Laurclavagh Renewable
Energy Development

***AN COIMISIÚN PLEANÁLA
FURTHER INFORMATION
REQUEST***

Our Case Number: ABP-319307-24

Re: Proposed no 8 wind turbines and associated works.
Laurclavagh and adjacent townlands, Co. Galway. (www.laurclavaghplanning.com)

PROJECT TITLE:			
Laurclavagh Renewable Energy Development, Co. Galway			
DRAWING TITLE:			
Proposed access junction off the L-61461			
PROJECT No.:	DRAWING No.:	SCALE:	
210627	210626 - 39	1:1,000 @ A3	
DRAWN BY:	CHECKED BY:	DATE:	REVISION.:
JOB	TH	13.03.2024	P01

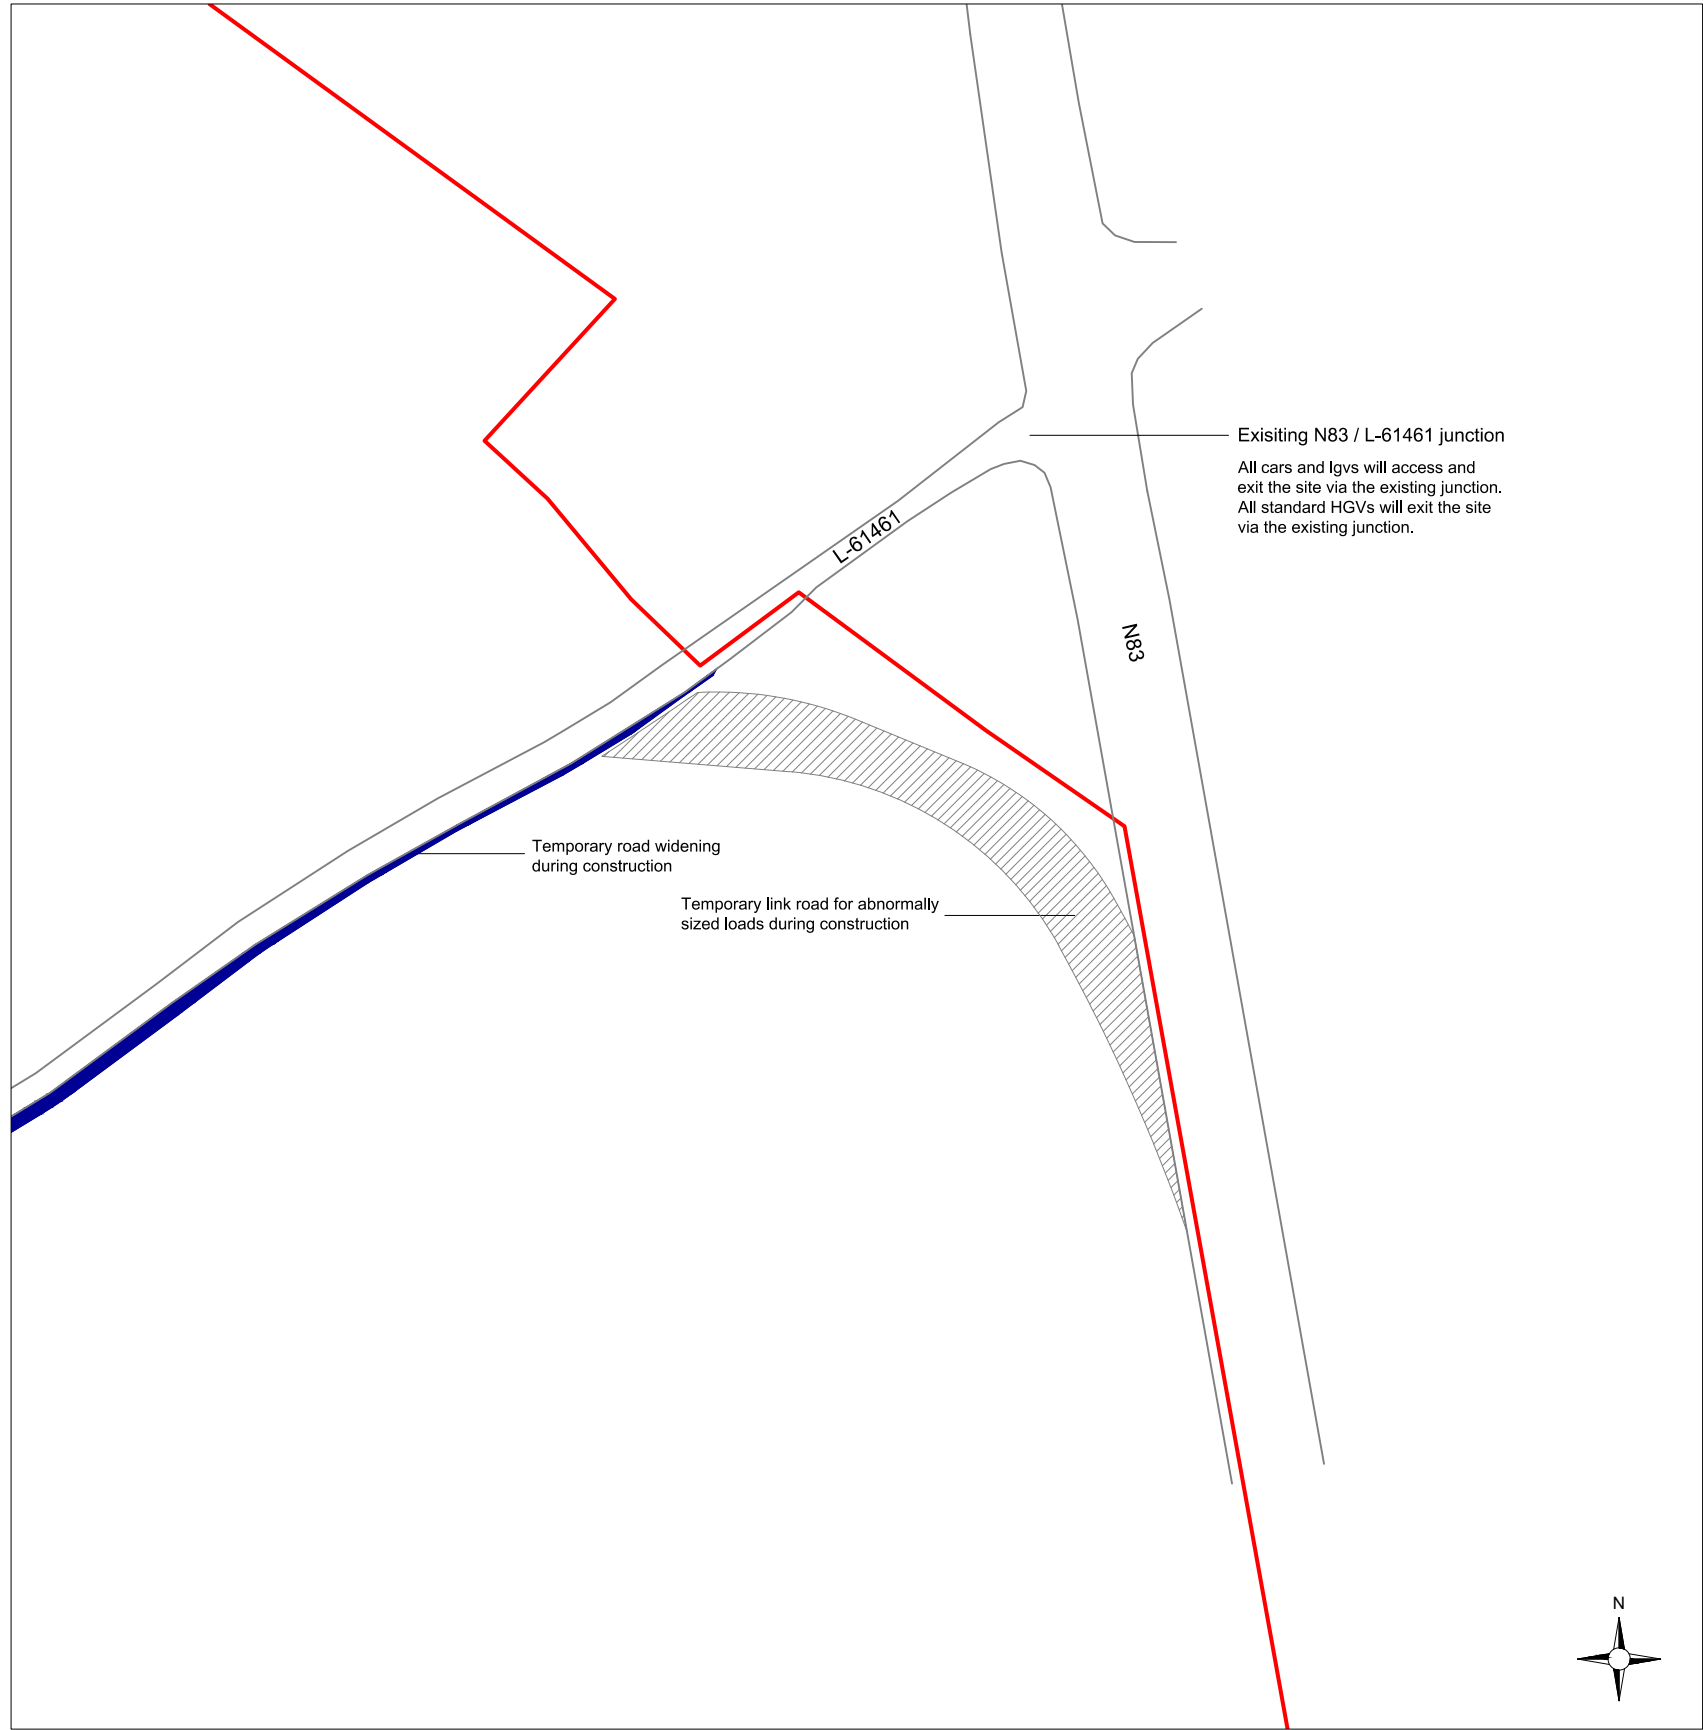
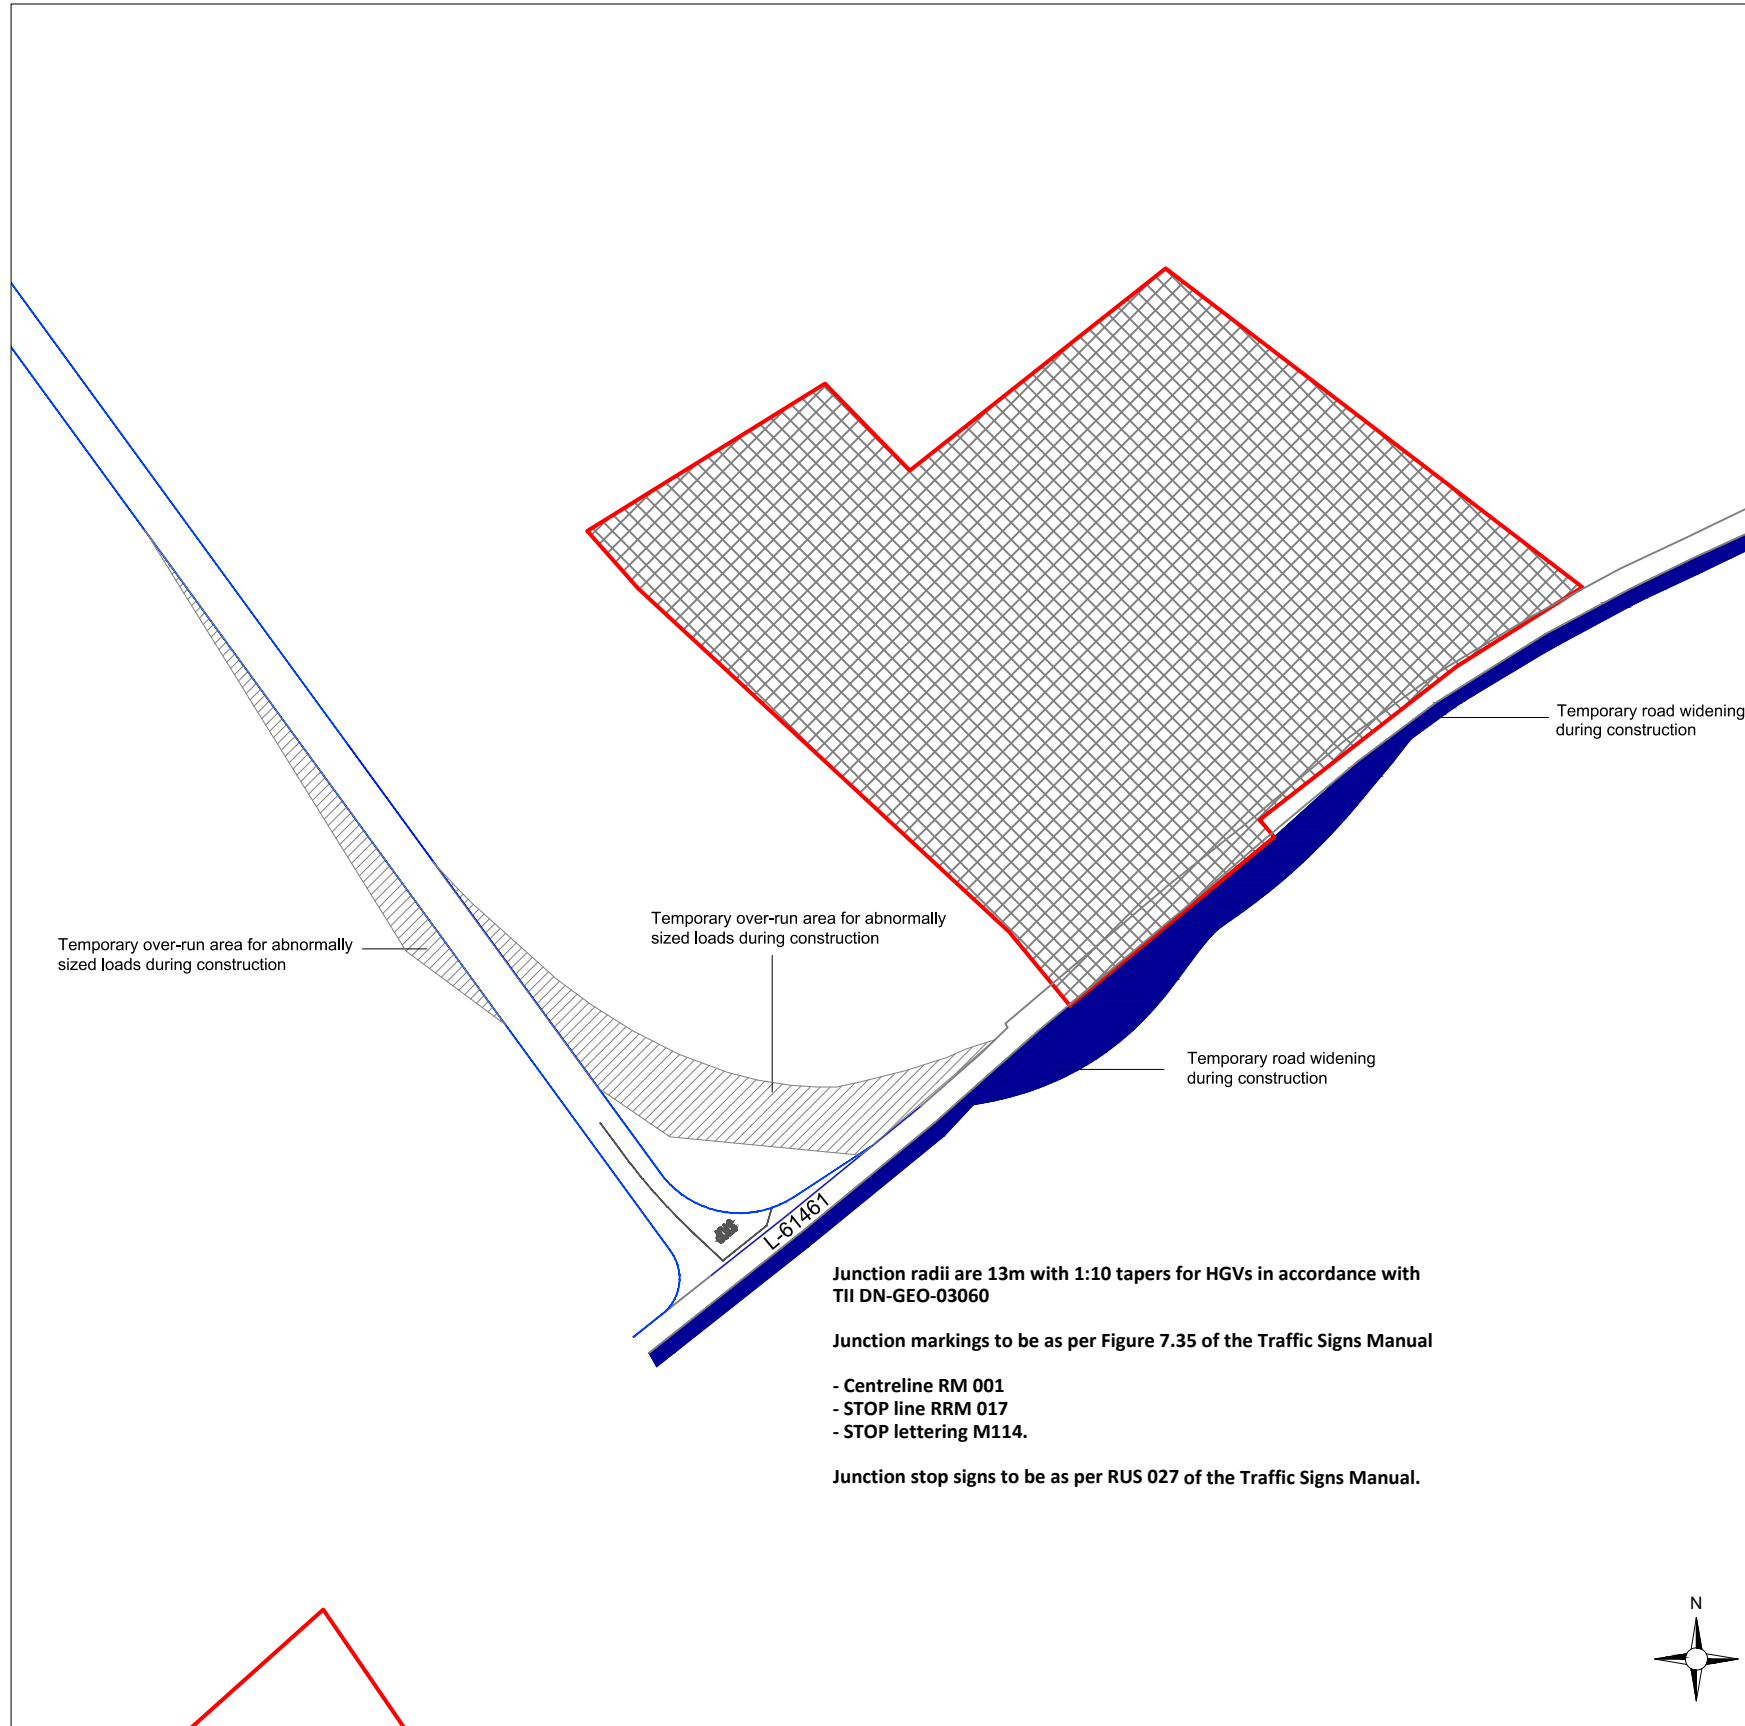
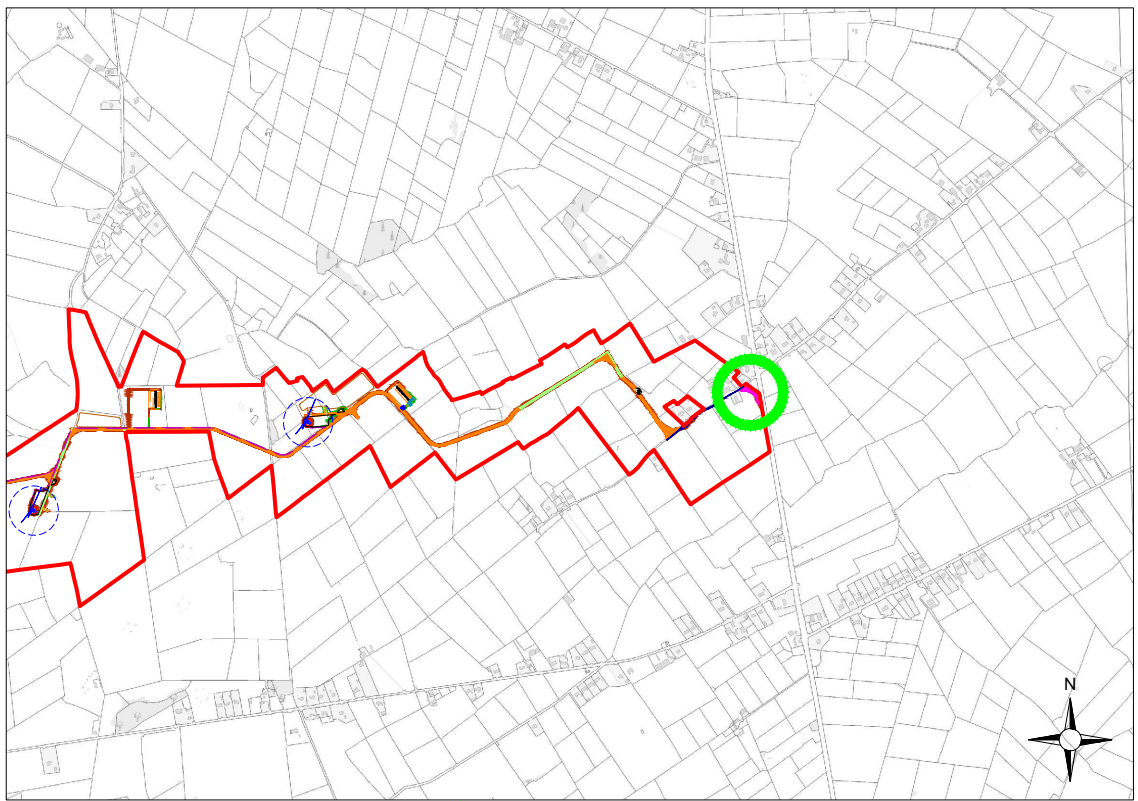
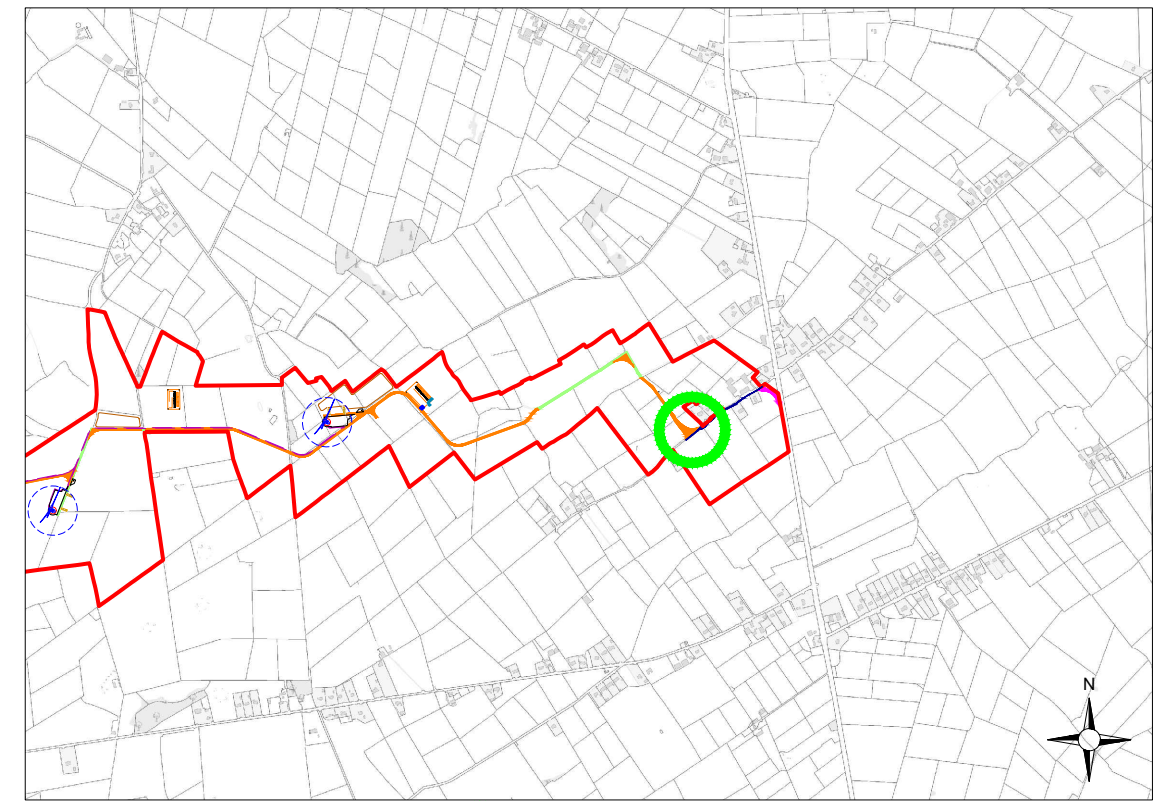
- 1.1 The N83-L61461 junction layout as outlined in submitted plans, the traffic management plan and in your response to submissions do not appear to be consistent with the existing onsite arrangement. The existing junction layout appears to display restricted sightlines in both northerly and southerly directions onto the N83. Given the application details submitted to date and the existing junction layout, consultation should take place with the planning authority in order to clarify the status of the existing junction layout.
- 1.2 You are requested to submit a revised site layout plan at an appropriate scale indicating clear sightline triangles at the required standard including at the N83 & L61461 junction. This shall

clearly dimension the extent of proposed boundary walls to be set back adjoining the L61461 and adjoining the N83. Sightlines at all entrances and junctions should meet required standards.

- 1.4 Site layout plans should be revised to clearly detail the width of L-61461 and its proposed widened areas, at an increased scale, taking into account the width of 2 number passing HGVs.

- 1.5 The site layout plans should be revised to detail existing junction layouts at the N83-local roads.
- 1.6 The proposed wind farm development would appear to adjoin/encroach onto third party lands adjoining the L61461, with existing dwellings not delineated on the site layout plans at this location. You are requested to provide clarification on same, and submit relevant consents if/where applicable, with plans revised to detail existing dwellings.
